**KIRKLEES METROPOLITAN COUNCIL
INVESTMENT & REGENERATION SERVICE**

DELEGATED DECISION TO DETERMINE PLANNING APPLICATIONS

Reference No:	2025/62/93069/E
Site Address:	25-27, Foundry Street, Dewsbury, WF13 1QW
Description:	Alterations to convert two shops to one shop on ground floor with installation of replacement shop fronts and two apartments on first floor (within a Conservation Area)
Recommending Officer:	Edward Cheseldine

DECISION - REFUSED

PROPOSED SIDE ELEVATION

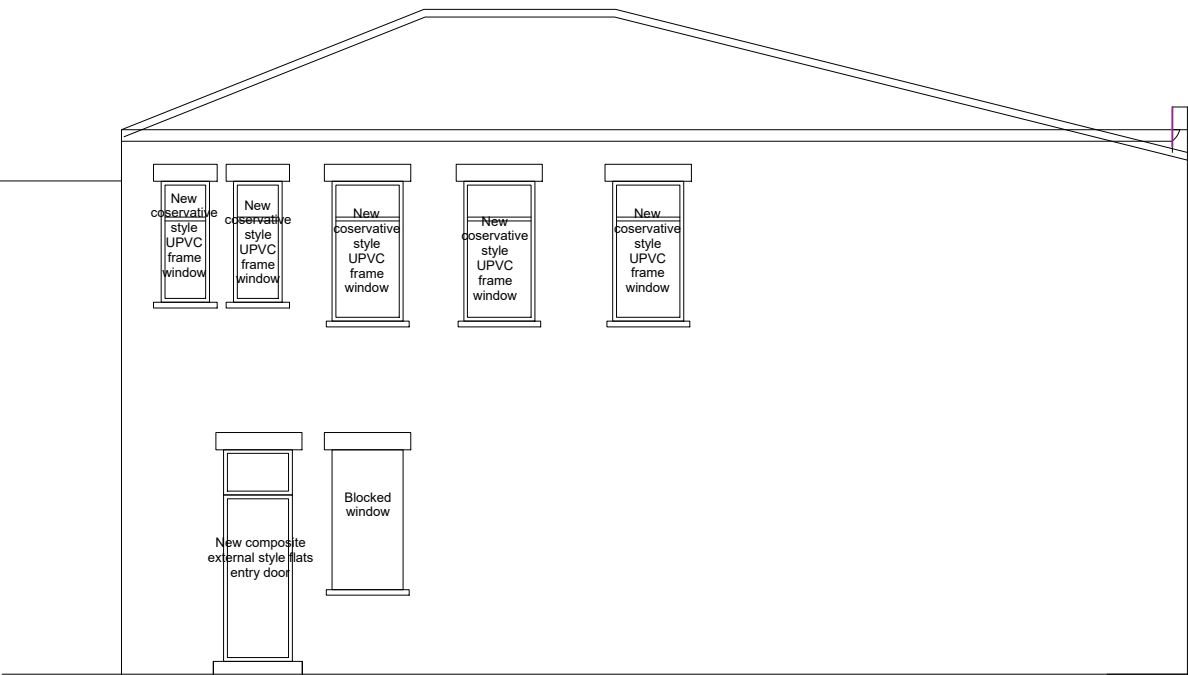
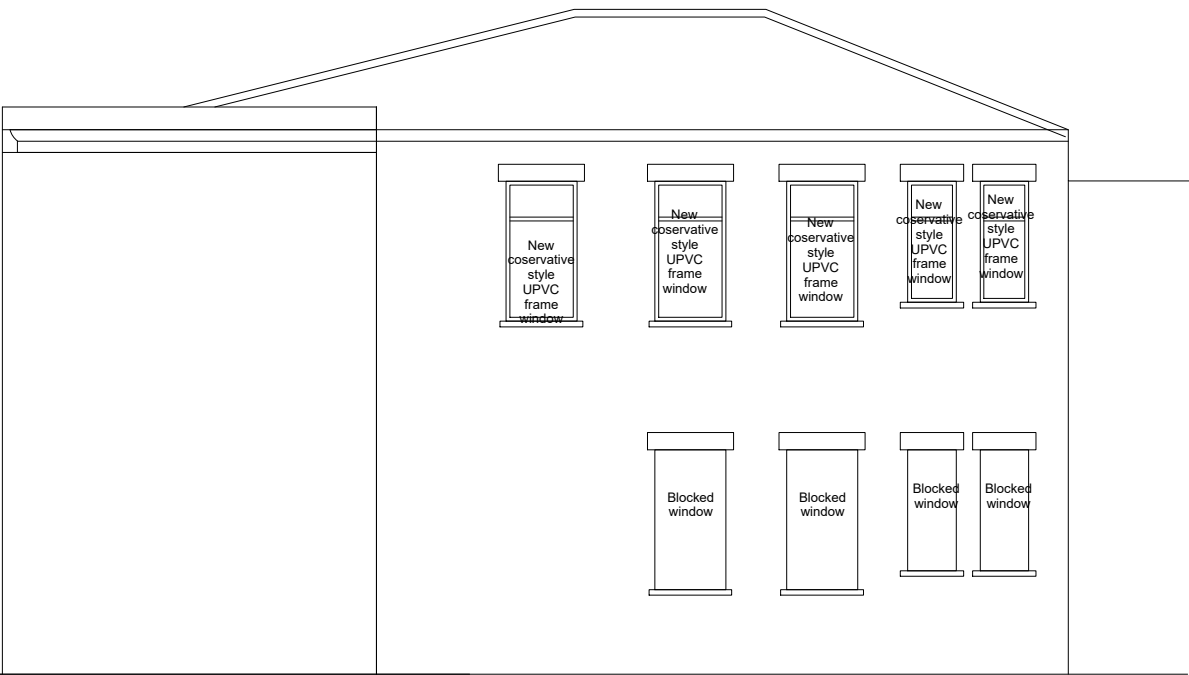
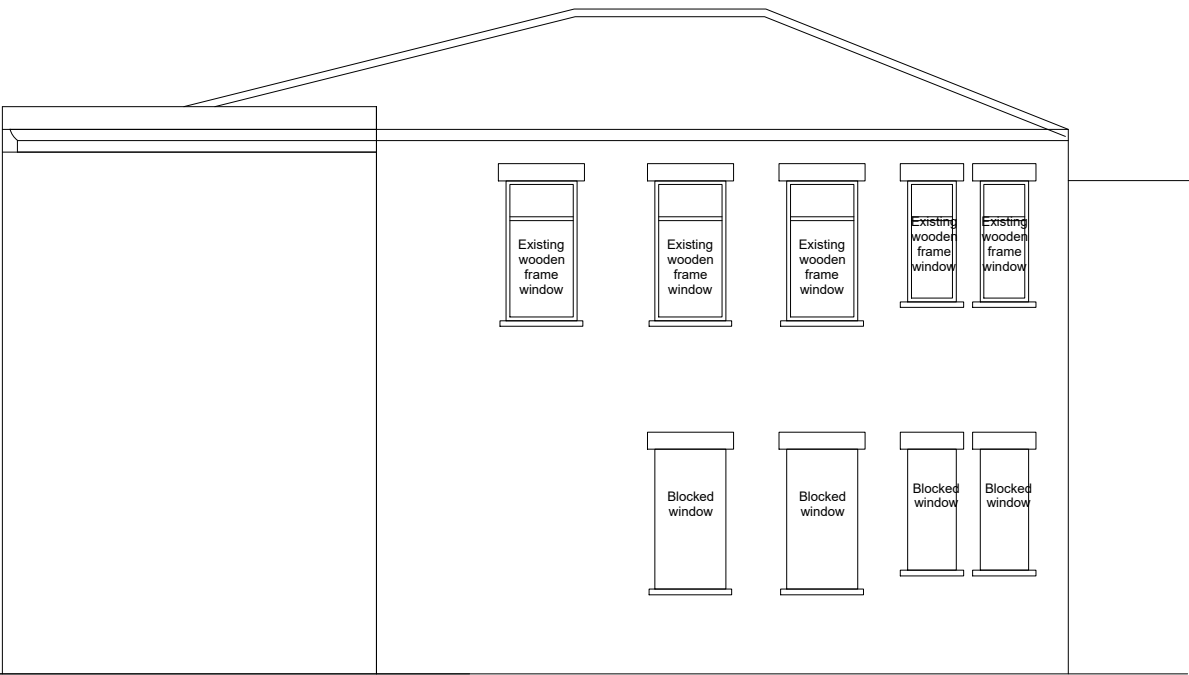
There are additional alterations proposed on the side elevations of the building, replacing the existing wooden frames windows with 'conservation style' upvc frames and replacing the wooden door with a composite door. Details of the replacement have not been provided. In any event a condition would be set for these details to be provided and approved by the LPA.

PROPOSED FRONT ELEVATION

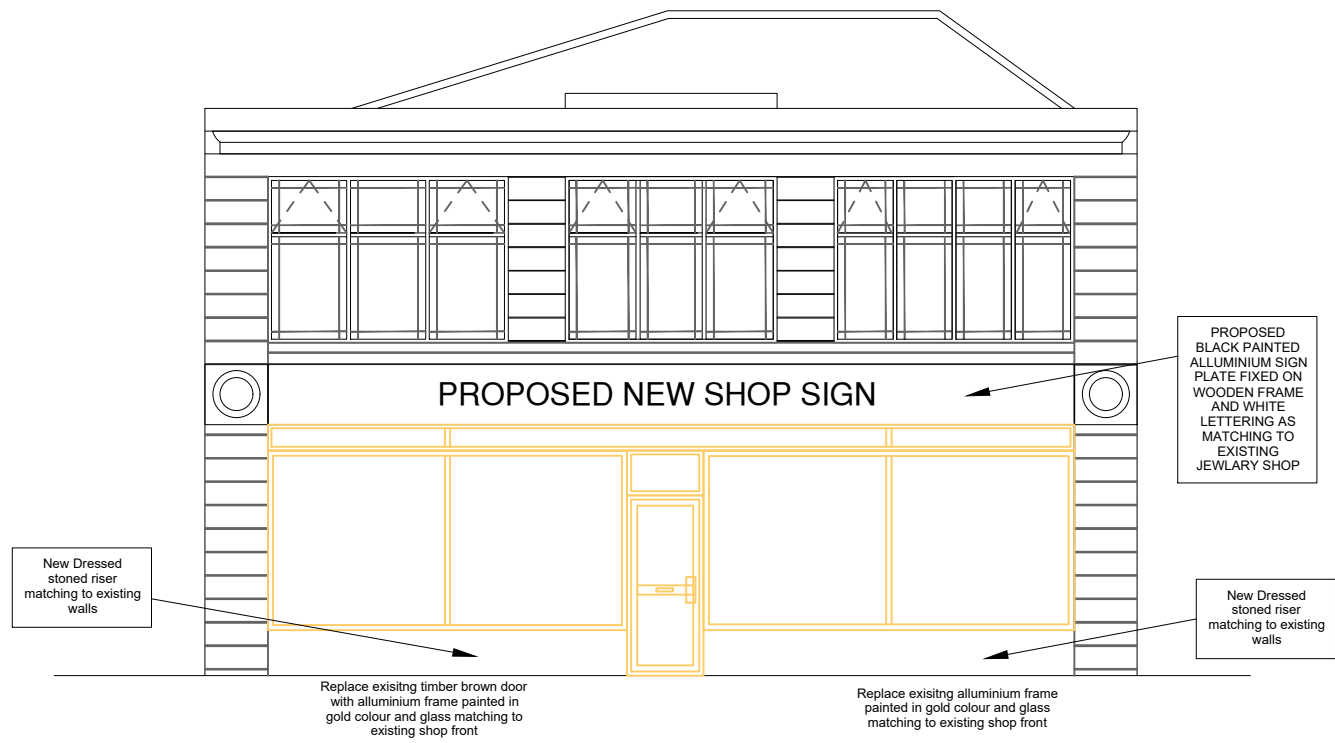
The proposed shopfront will remove historic detailing from the building and the restored shopfront which is in a style contemporary with the original building.

Wooden window frames and doorways will be replaced with a single frontage formed with modern materials, resulting a loss to detailing and character. The materials present are inappropriate resulting in a modern appearance conflicting with the traditional features and appearance of the building. The existing shopfront adjacent includes wooden window and door frames painted

Remnants of the historic detailing will be removed from the design of the shop front. This will include the removal of central stained-glass features, recessed doorways, wooden door frames and floor tiles.

The development, in respect of materials and design of the shopfront on the front façade would present less than substantial harm to the significance of the wider conservation area. Due to the proposed harm, it should therefore be considered if there are any public benefits to the proposal as per paragraph 215 of the NPPF.

This application, however, removes all traditional features from ground floor of the principal elevation of the building harming the special interest of the Dewsbury Town Centre Conservation Area, public benefits would not outweigh such harm.

1. Due to the design and materials proposed the alterations to the shopfront façade would fail to respect the special appearance and character of the host building and wider building group, harming the significant historic interest of the building and Dewsbury Town Centre Conservation Area. The development fails to preserve or enhance the character, or setting of the designated heritage asset, being contrary to Sections 72(1) of the Planning (Listed Buildings and Conservation Areas) Act 1990. It would result in less than significant harm to the significance of a designated heritage asset for which no public benefits have been demonstrated that would outweigh this harm contrary to Chapter 16 of the NPPF (paragraphs 212 & 215) and Policies LP1, LP2, LP18, LP24 and LP35 of the Kirklees Local Plan.

- Reduce the size of the fascia to match the level of the stone feature on the side columns.
- Maintain the recessed doorway, revealing original tiles on floor level
- Maintain one wooden door on the front façade
- Retain and extend the wooden window frames
- Materials details of the riser and fascia to be in keeping with the Conservation Area and host building.
